Your Ref: OWPC18124
Our Ref: LU/81/18/HH 23-03-2018
Please ask for:
Amber Willard

Single storey rear extension & new vehicle access.
31 North Ham Road Littlehampton

DRAWING	SCALE
BLOCK PLAN	1/200
DATE: MARCH 2018	
DRAWN: T. Murray	
DRAWING: 18/07/3	REVISION:

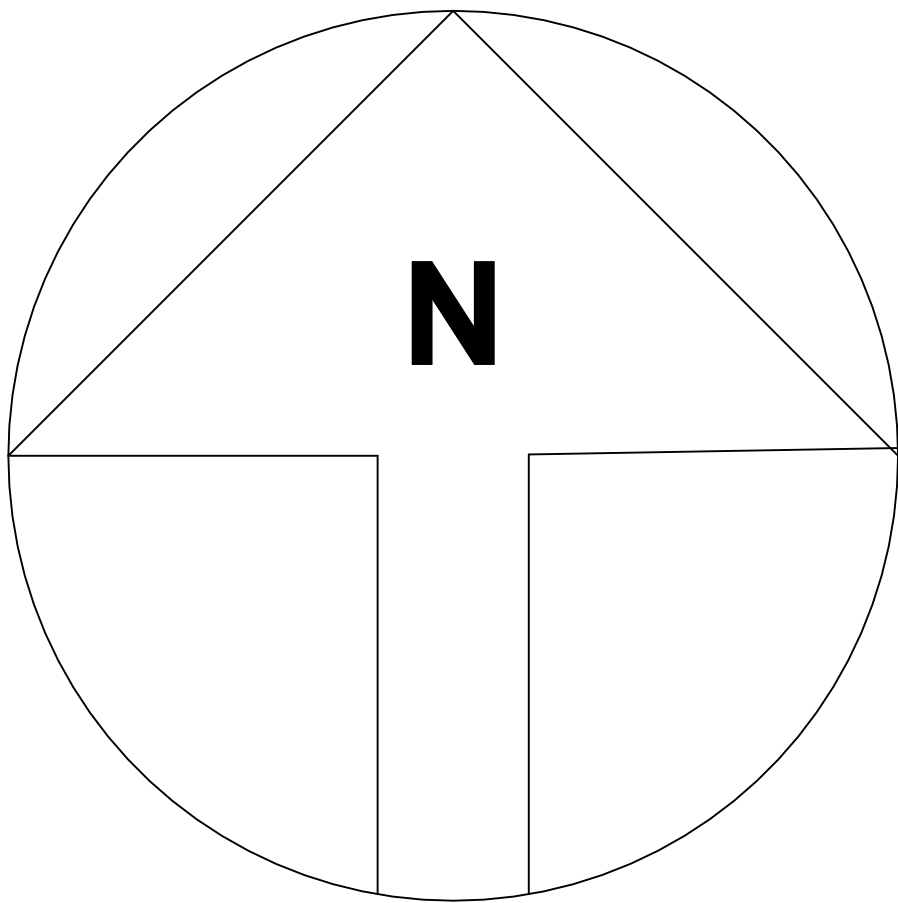
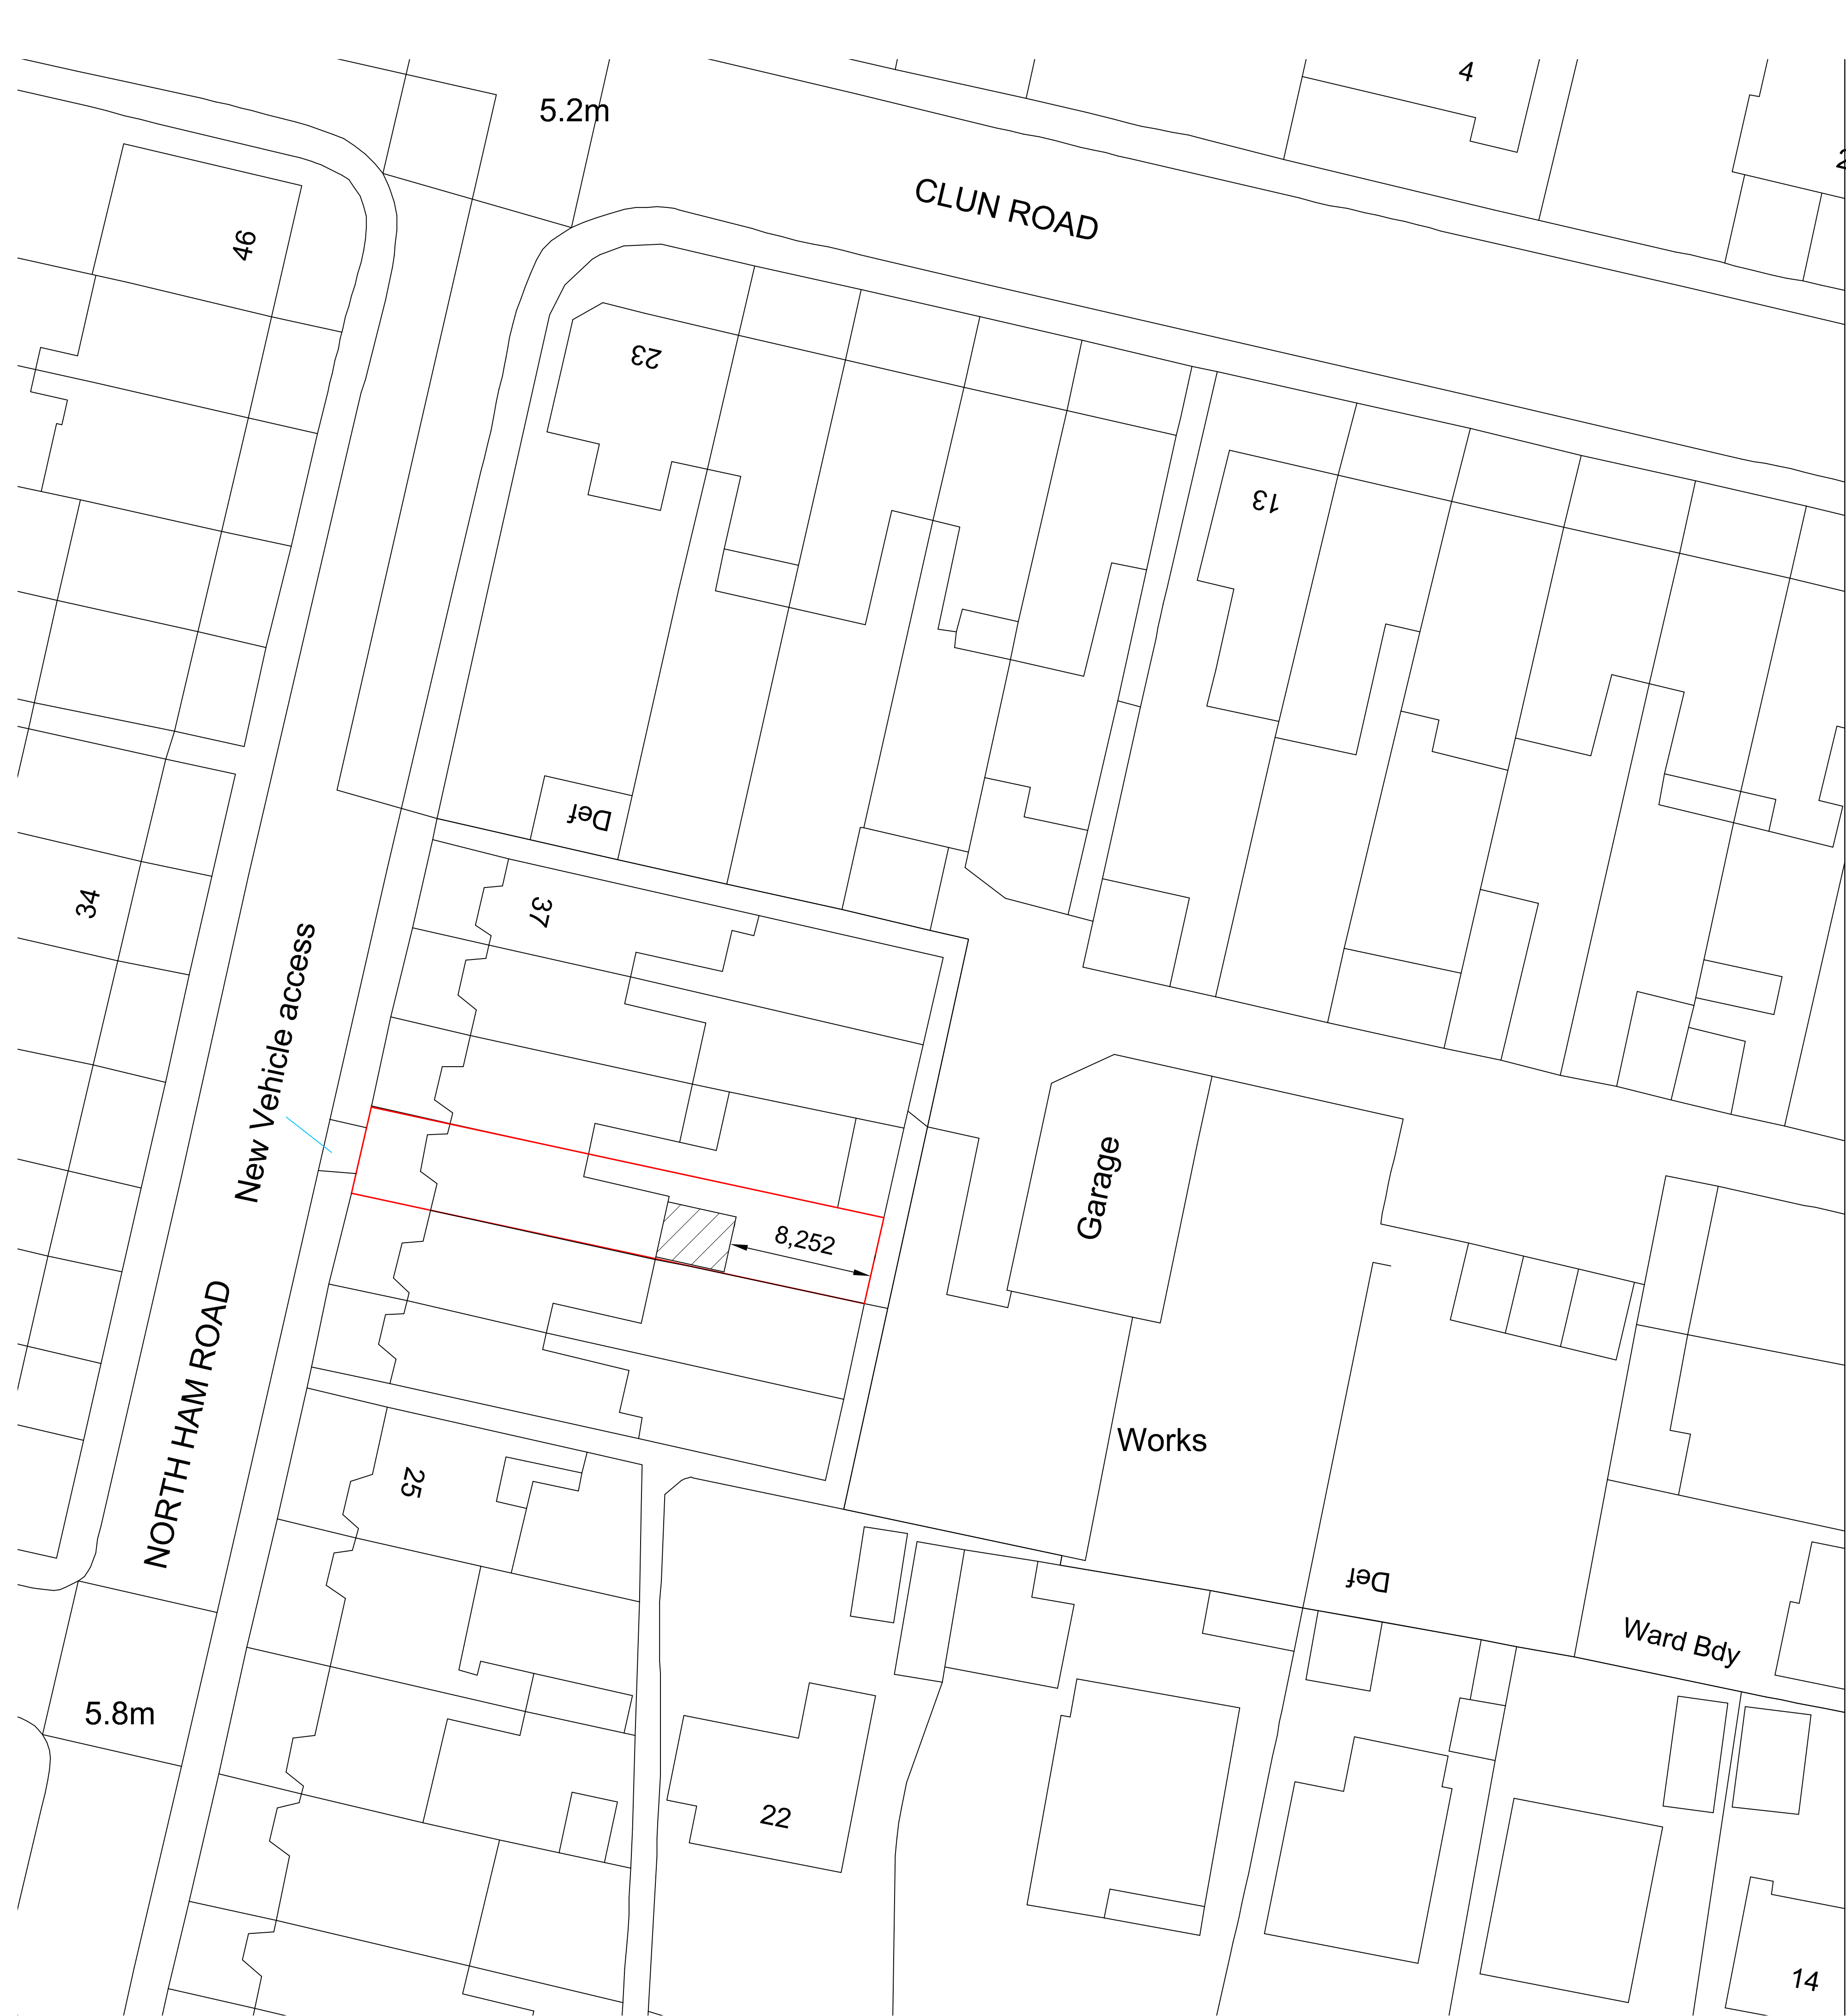
On behalf of the Littlehampton Heritage Group, of which I am the elected Chairman, we would object to the provision of New Vehicle Access as this will mean the removal of the Flint Wall outside this property.

In North Ham Road, the section from No 23 to No 37 is the last remaining fully intact stretch of front flint walls to the properties, in North Ham Road. Further destruction of these flint walls will see yet another needless attack on the Heritage of our Town.
